Neil Morgan on behalf of Slough MotoX Parc

WRITTEN REPRESENTATION

HIGHWAYS ENGLAND'S RESPONSE

- 1.1 *SLOUGH MOTOX - M4 JUNCTIONS 3 TO 12 SMART MOTORWAY - WRITTEN SUMMARY OF ORAL SUBMISSIONS PUT AT HEARING HELD ON 19TH NOVEMBER.*
- 1.2 *I apologise for the delay in submitting this written summary, however I have not received any correspondence to date setting out the Development Consent Order timetable. Please note our postal address below.*

Drawing title  
SIDE ROAD PLAN & PROFILE  
REGULATION 4(2) (e)  
SHEET 11 OF 13  
RECREATION GROUND ROAD

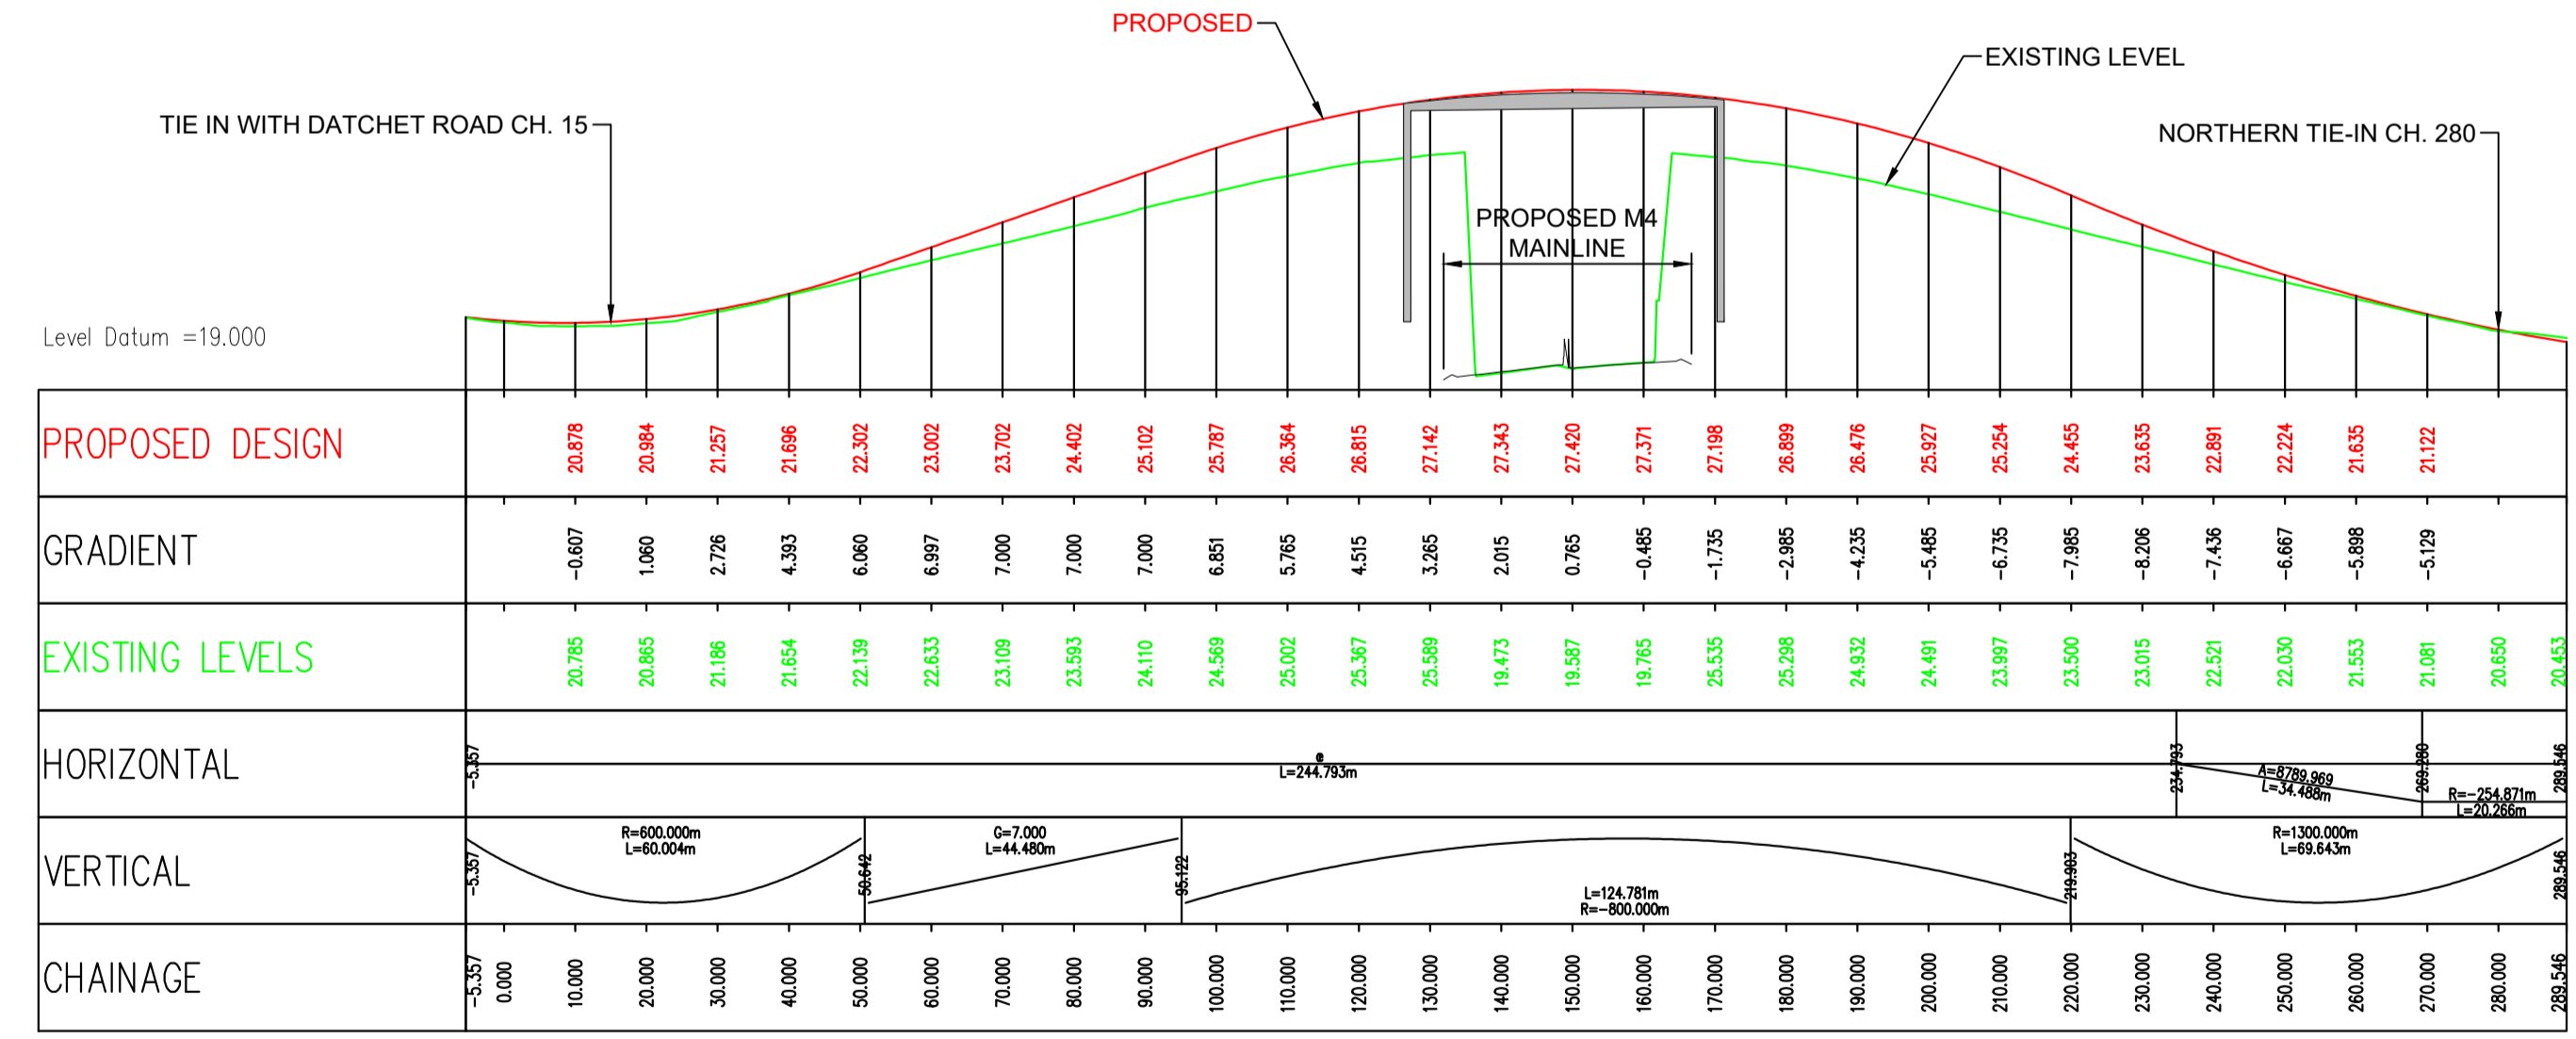
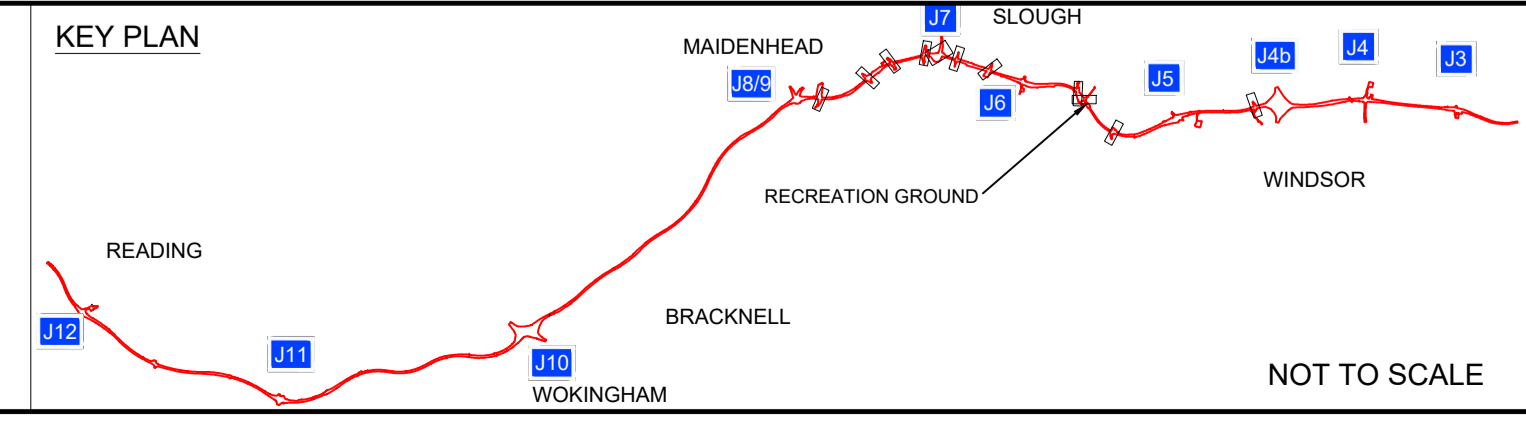
- 1.6 *We also have major concerns that increasing the height of the bridge and road leading to and from it on the park side will increase the fall, resulting in a wider embankment being needed and permanently reducing the track size. The current engineering proposals do not account for noise and security bunds on the site that run alongside the fall, and along with the increase of the fall will need to be an increase in the bund, which we believe will impact on a large section of the track.*

- 1.6.1 It is correct that the increase in the span of Recreation Ground Bridge will make the new bridge up to 1.1 metres higher and this means that the footprint of the embankment will increase. Consequently, the security fence required to contain and secure the activities of the Slough MotoX Parc is likely to require amendment which may reduce the available track areas. At present, the geotechnical investigation and detailed design have not been completed so the extent of the changes to the embankment cannot be quantified precisely. However, the toe of the new embankment will not extend any further than the limits shown on the Works Plans (REP5-006) and on the schematic land area plan overlaid on Google Earth provided to Slough MotoX on 16 December 2015 and 12 January 2016, and appended to this response at Appendix A.

- 1.6.2 Highways England will continue to engage with Slough MotoX during the detailed design phase so that it is aware of the proposed works and in order to try and minimise the impacts on the facility as far as possible. This commitment will be secured in the revised version of the CEMP to be submitted at Deadline VIII.
